JOHN HUNTER HEALTH AND INNOVATION PRECINCT

SSD-9351535 Council Comments

Attachment A – SSD-9351535 Further Council Response Letter

38 LOOKOUT ROAD, NEW LAMBTON HEIGHTS - JOHN HUNTER HEALTH AND INNOVATION PRECINCT (SSD-9351535)

DRAWING TITLE  
**ASB BUILDING LEVEL 00 COURTYARD SECTIONS**

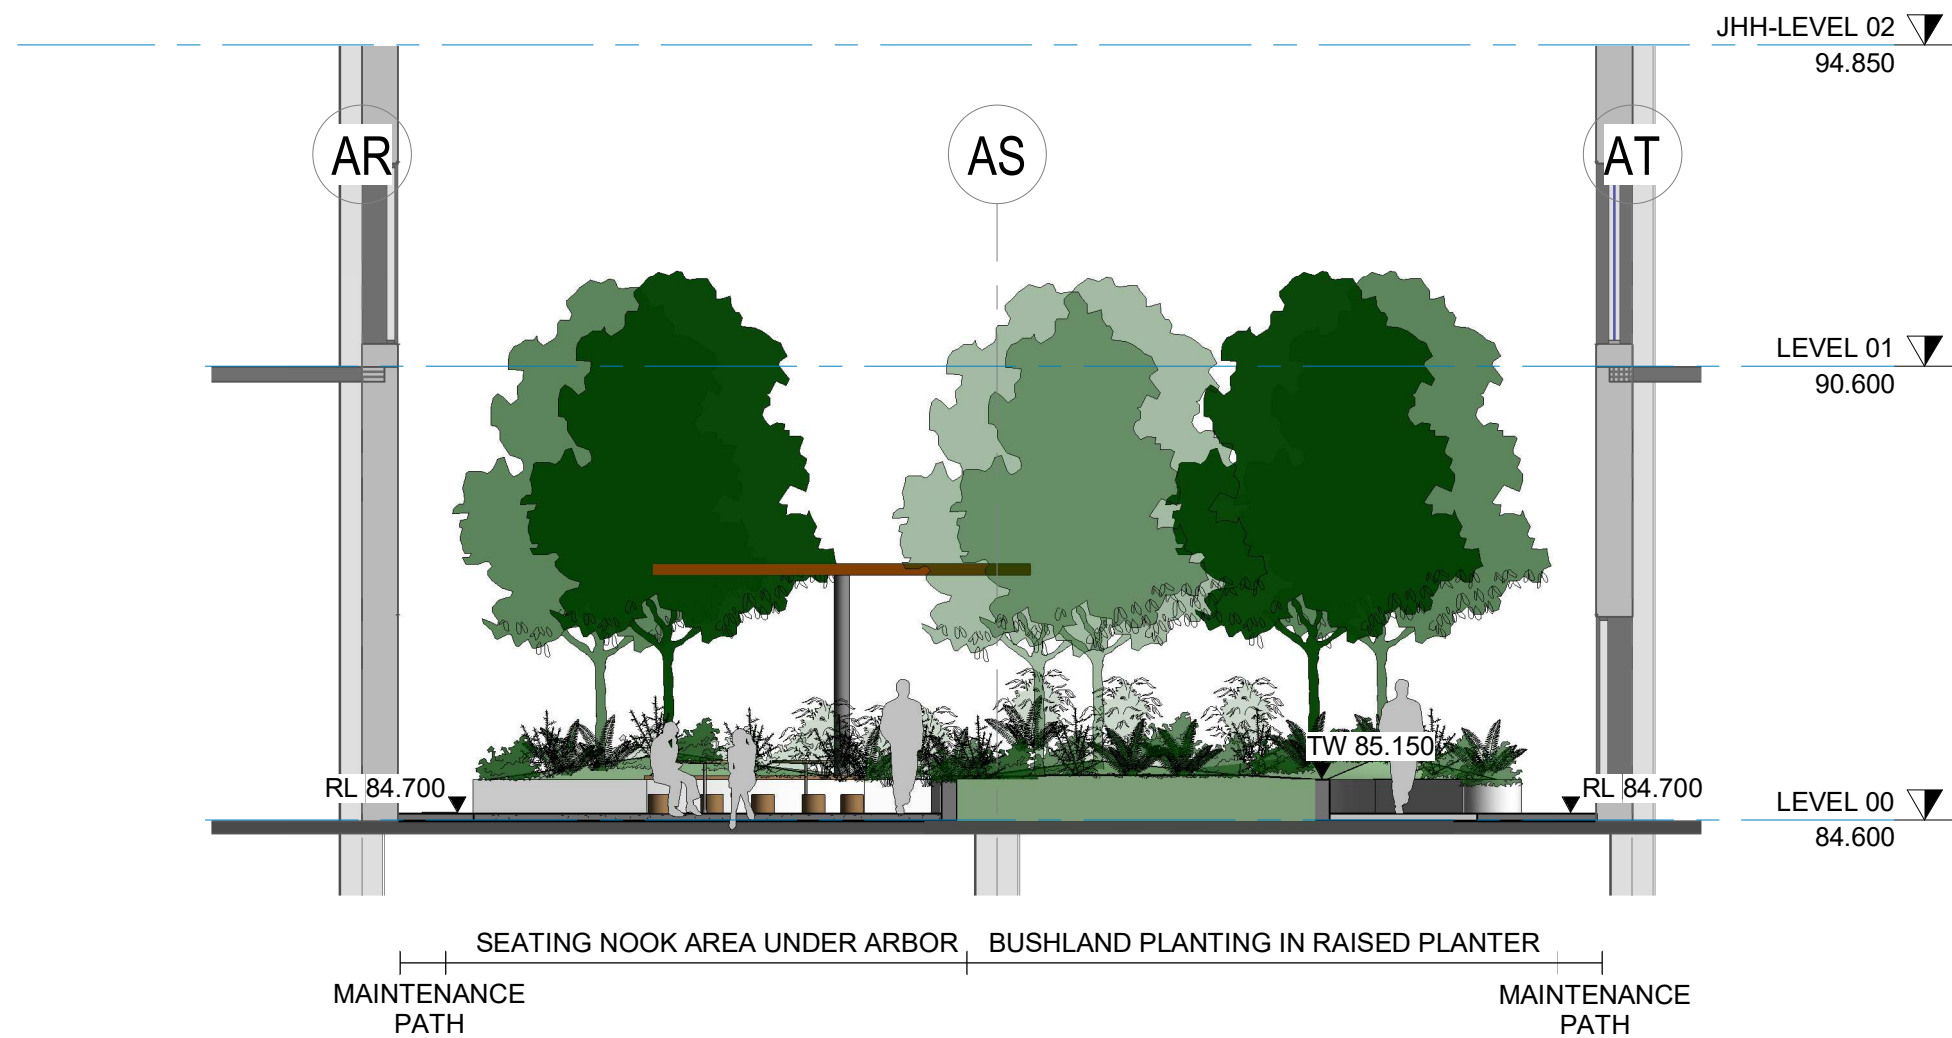
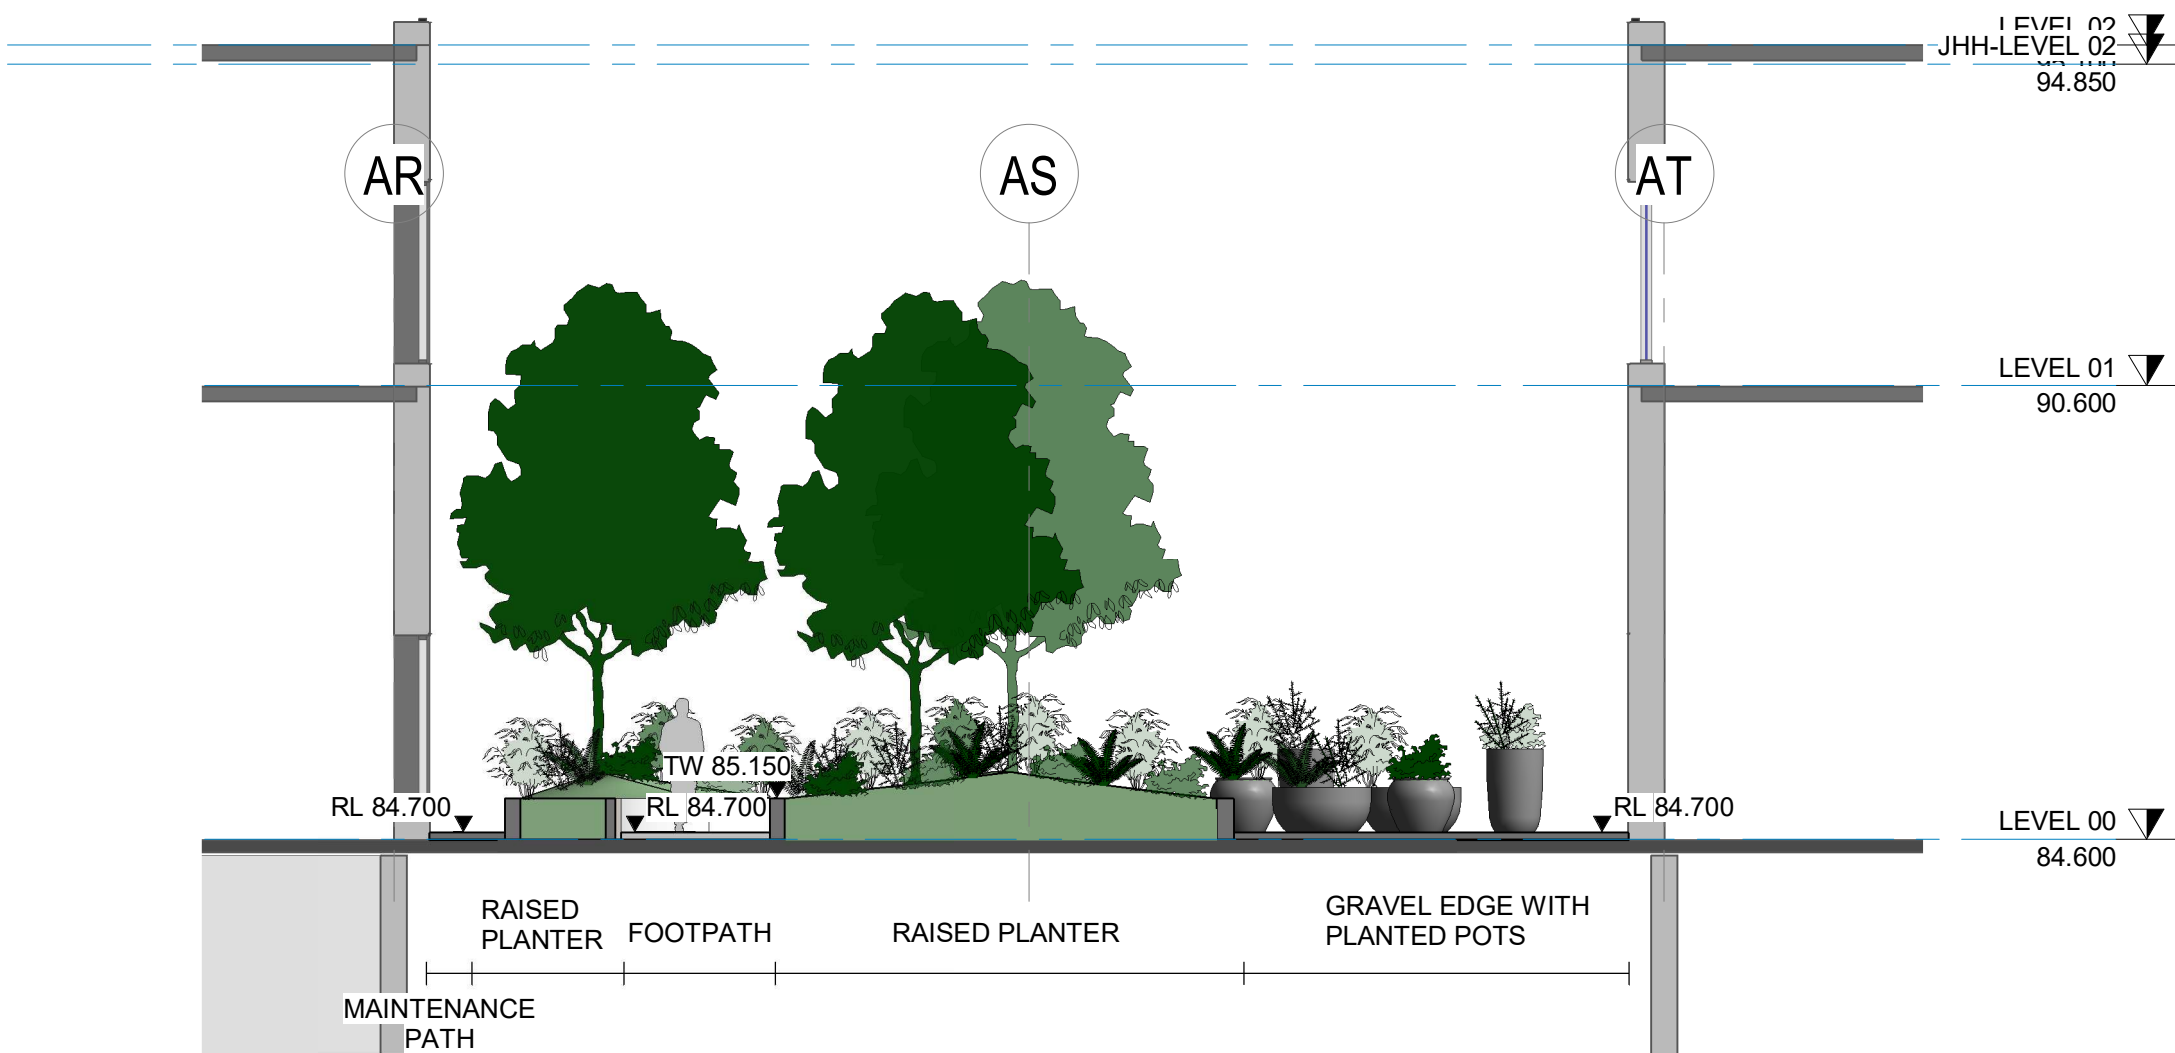
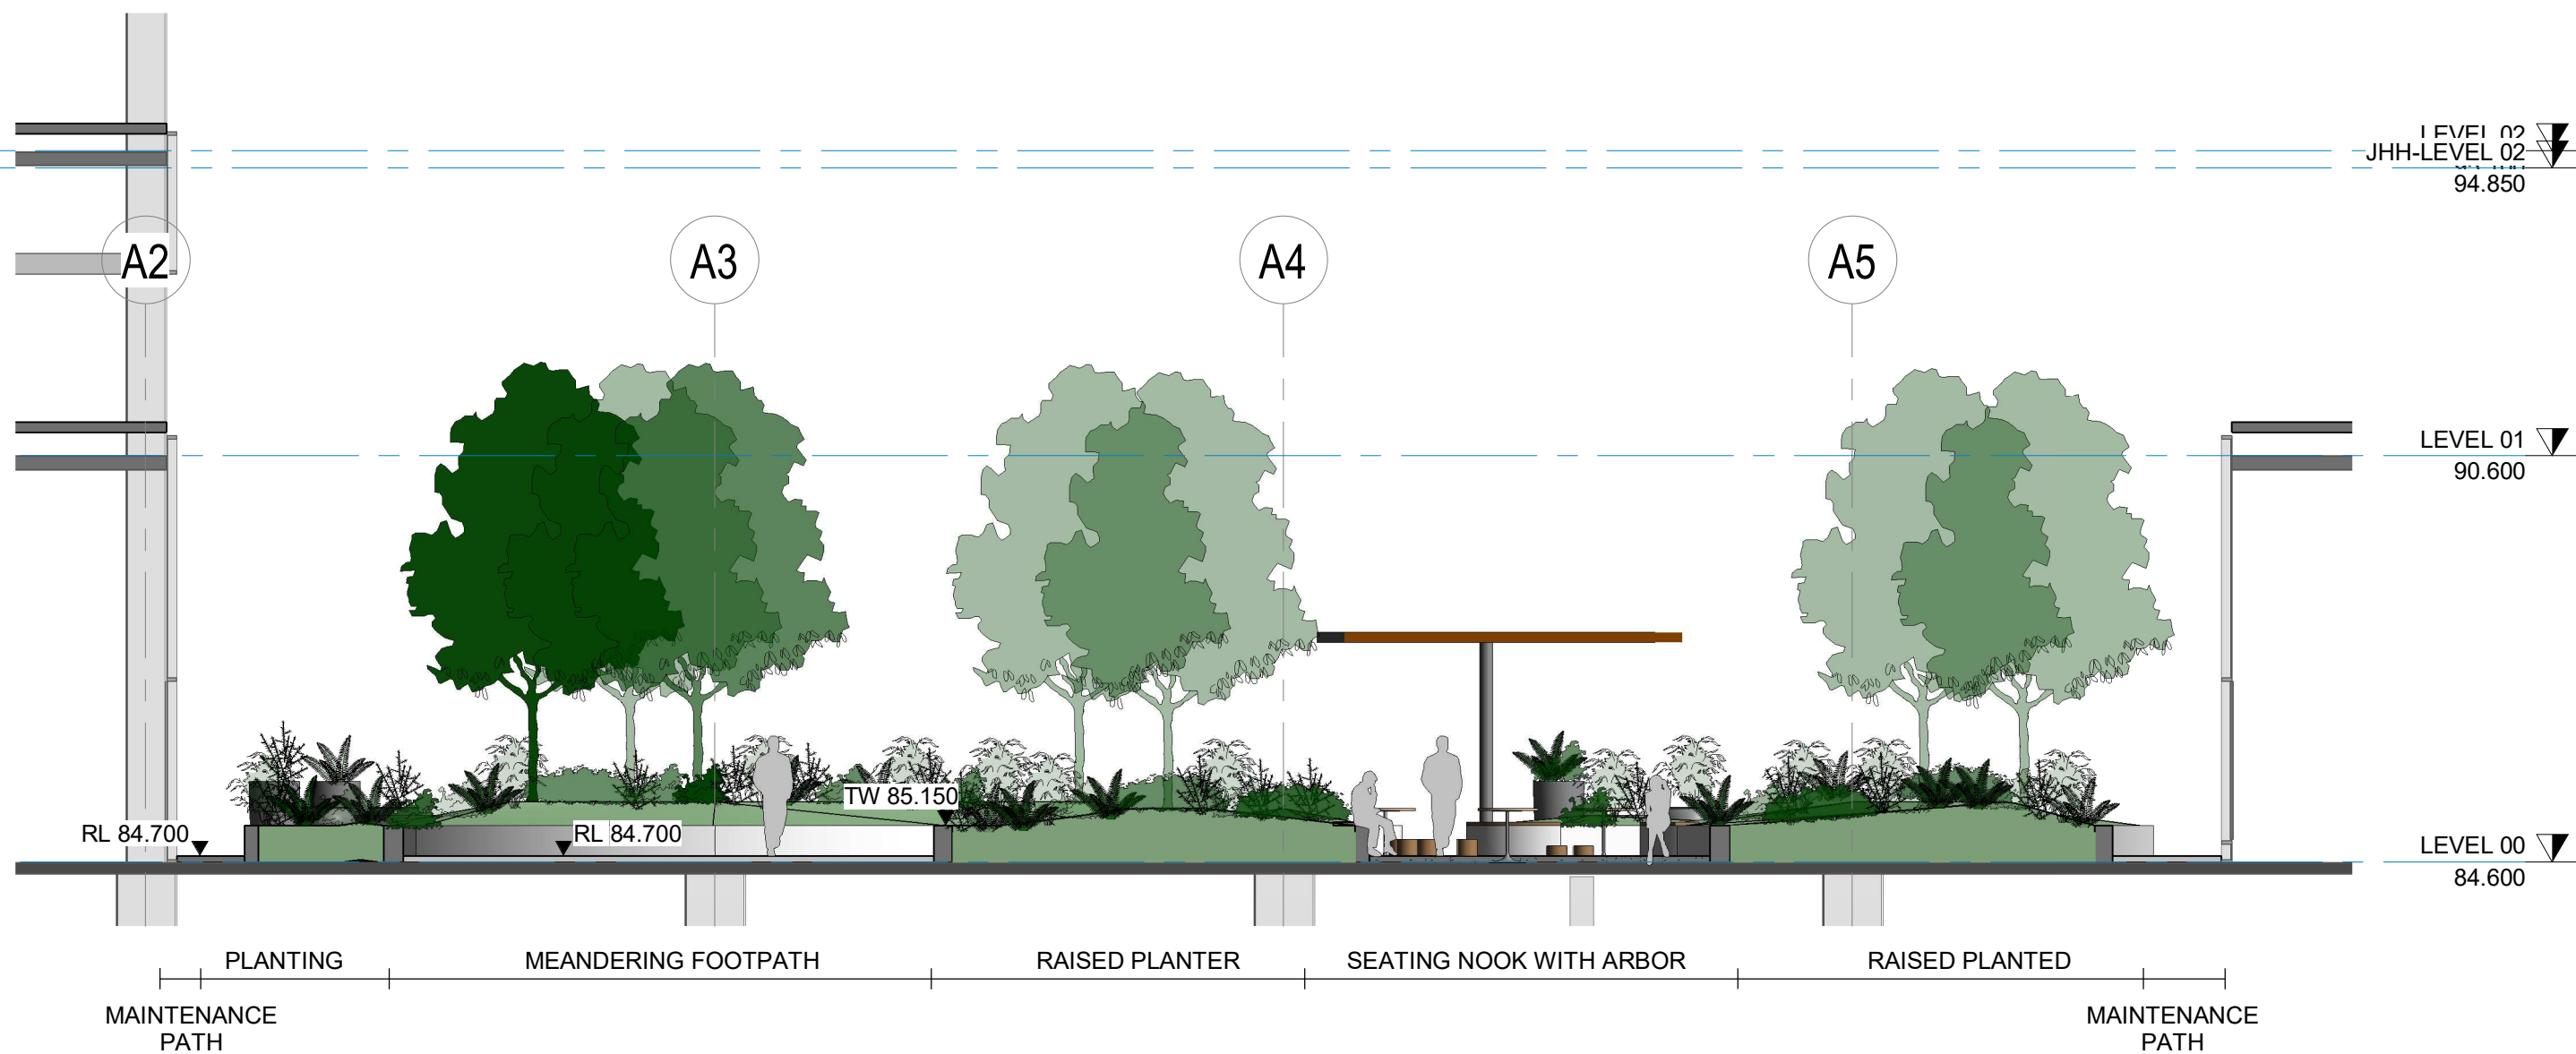
While CN generally does not have any concerns regarding this reuse proposal, it is noted that the development has a lot more potential for stormwater reuse than what has been proposed. The submitted Landscape Plan for the ASB Building Level 00 and Level 01 seems to be creating a great opportunity for a stormwater reuse.

Recent large-scale developments in the CN local government area have been reusing stormwater for similar landscape use, some of which have been very successful. At a minimum, it is recommended that an additional rainwater tank/s is provided for reuse of the landscaped areas.

4.3	<p><i>Key Actions</i></p> <p>Council were accepting that the following actions would meet their concerns.</p> <p>JHHIP to develop formal response to DPIE addressing:</p> <p>a) The project acknowledges and supports Council's suggested scour protection and approach. With final design detail to be shared prior to construction of this particular element.</p> <p>b) Reconfirm how the project has sized the reuse tank and provide further detail on its use with irrigation to landscaped areas of the building.</p>	Northrop / BVN / Ethos / APP	8/10/2021
5	Local Bushland Impacts	Note	-
